Re: Tramway Starbucks, 200 Tramway Blvd. SE
Traffic Impact Study final, dated August 2023
HT#L23D015A
Engineering Seal date 8/15/2023

Review of the Traffic Impact Study for Tramway Starbucks received August 15, 2023 has been completed by the City's Planning Transportation Development section. The City accepts and approves the TIS with the following recommendation for a minor infrastructure modification.

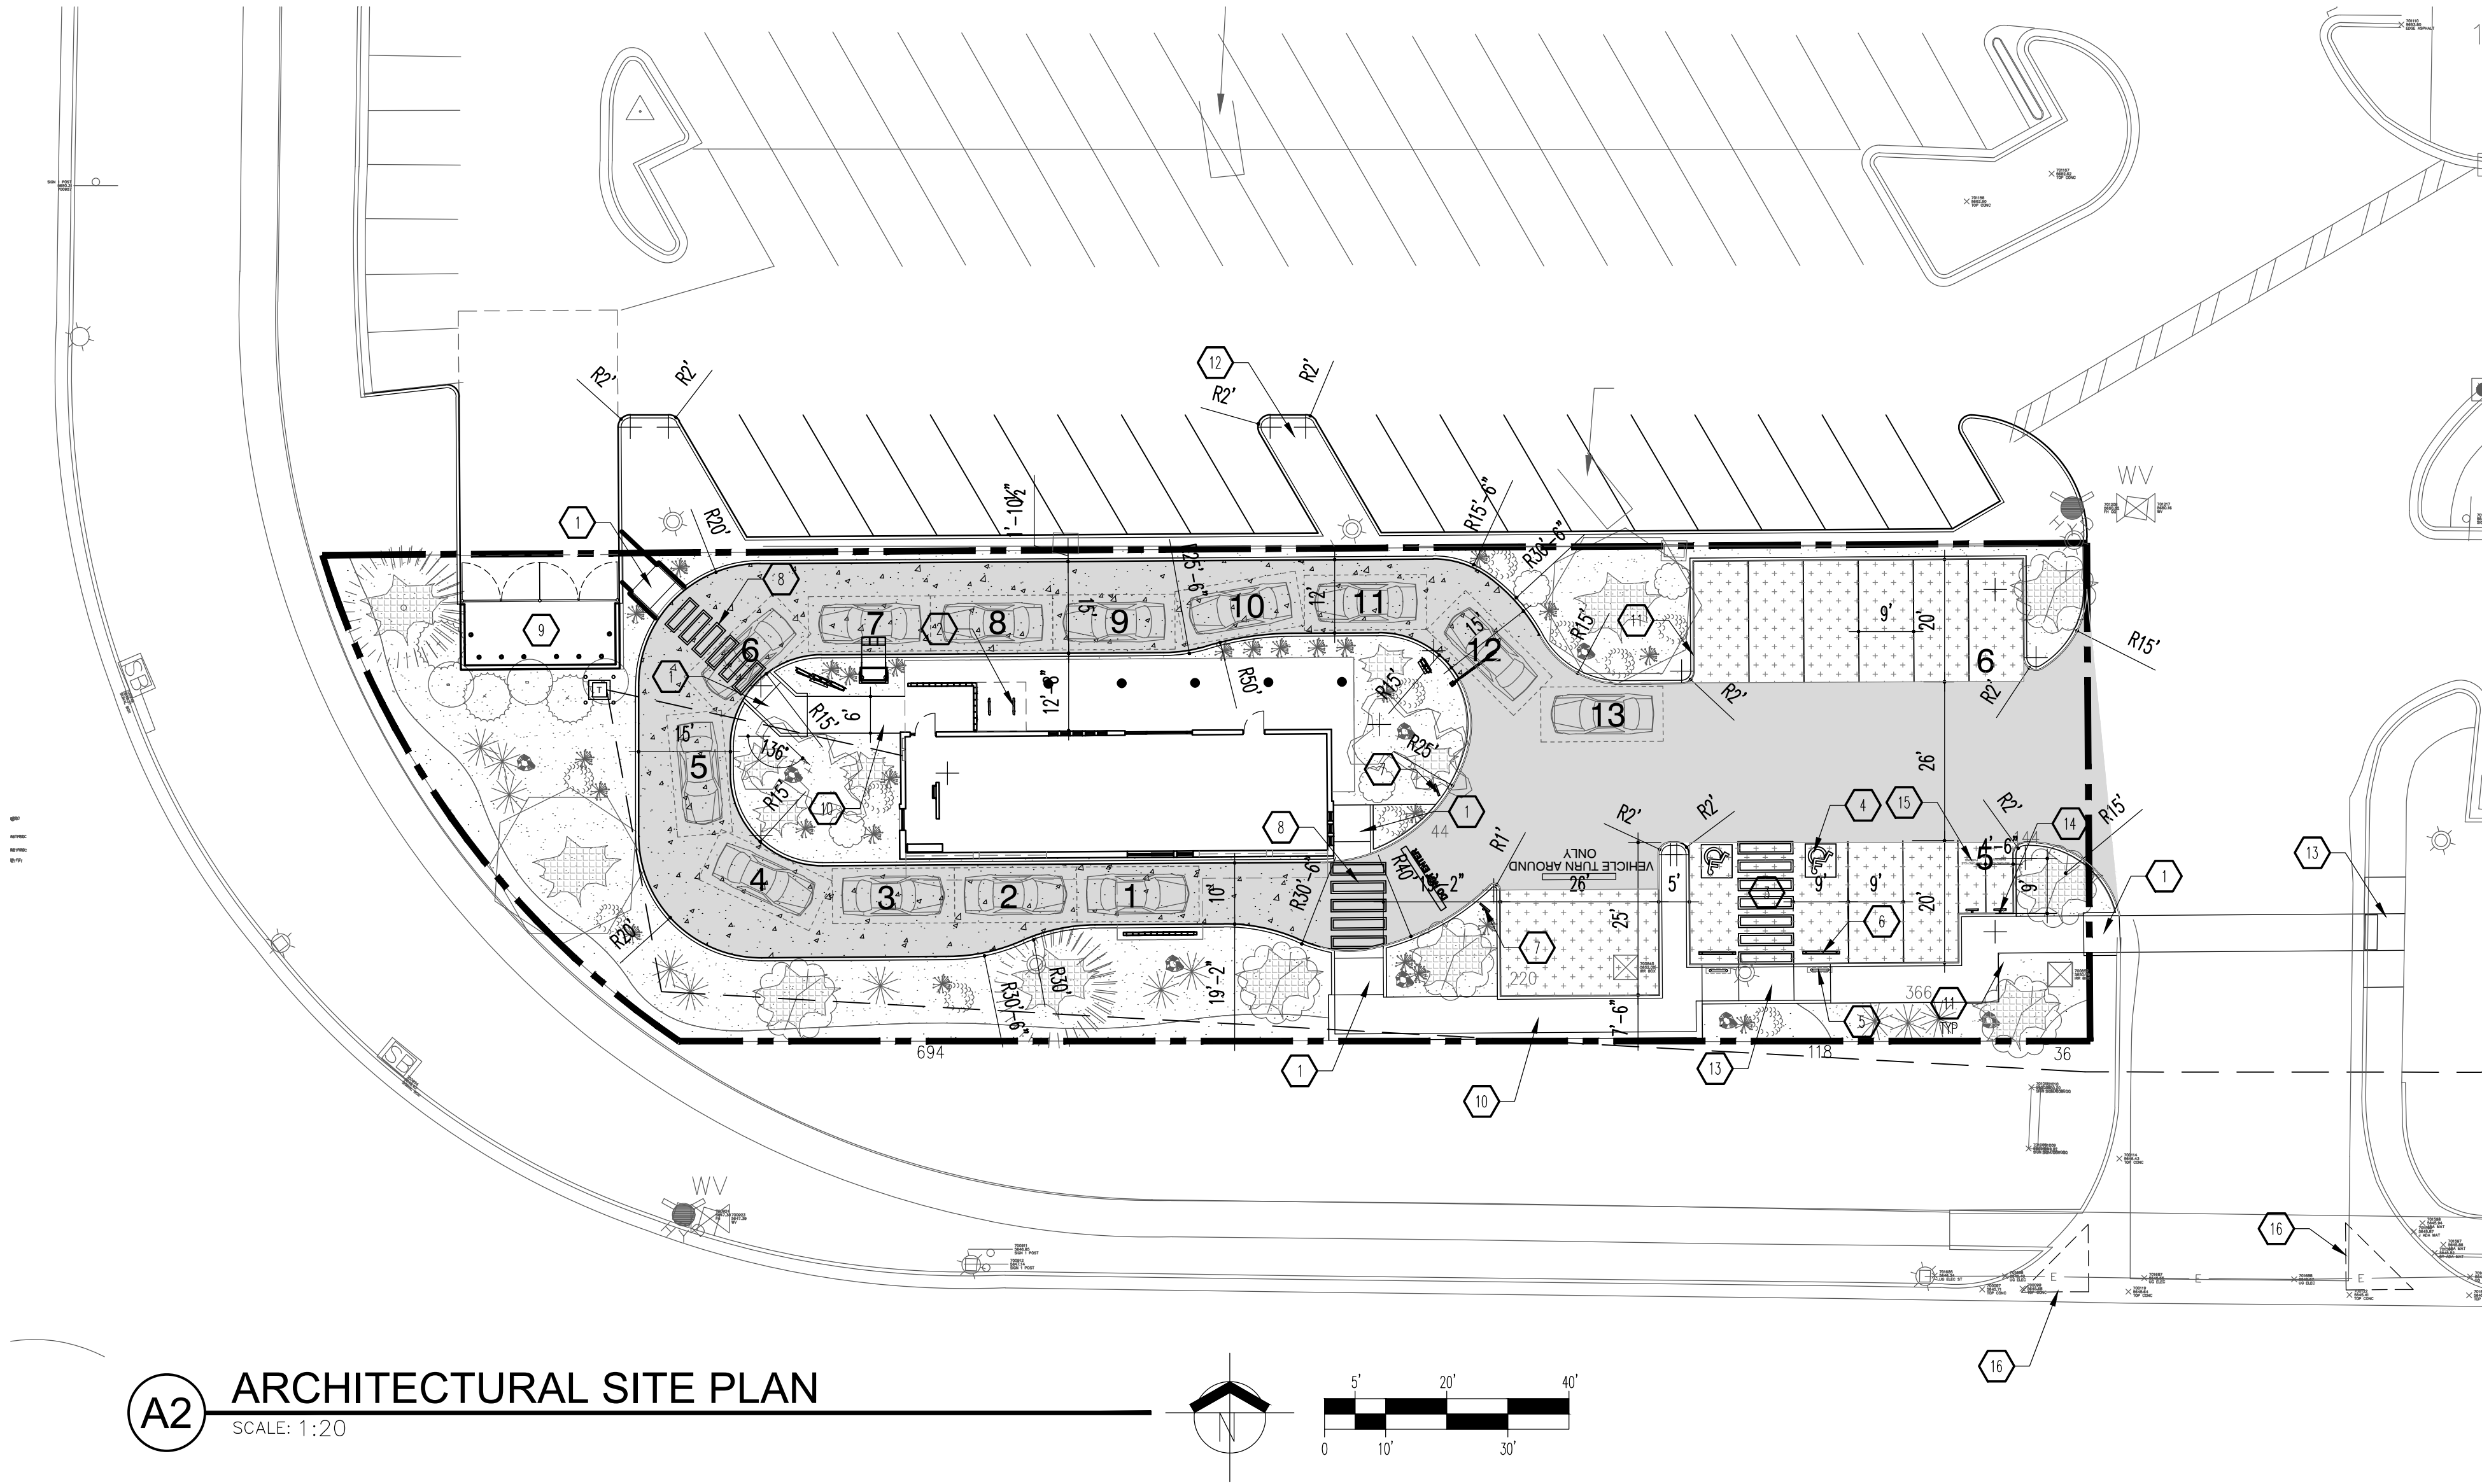
- The existing southbound left turn lane serving the site at the west driveway be lengthened to meet DPM design specifications as closely as possible.
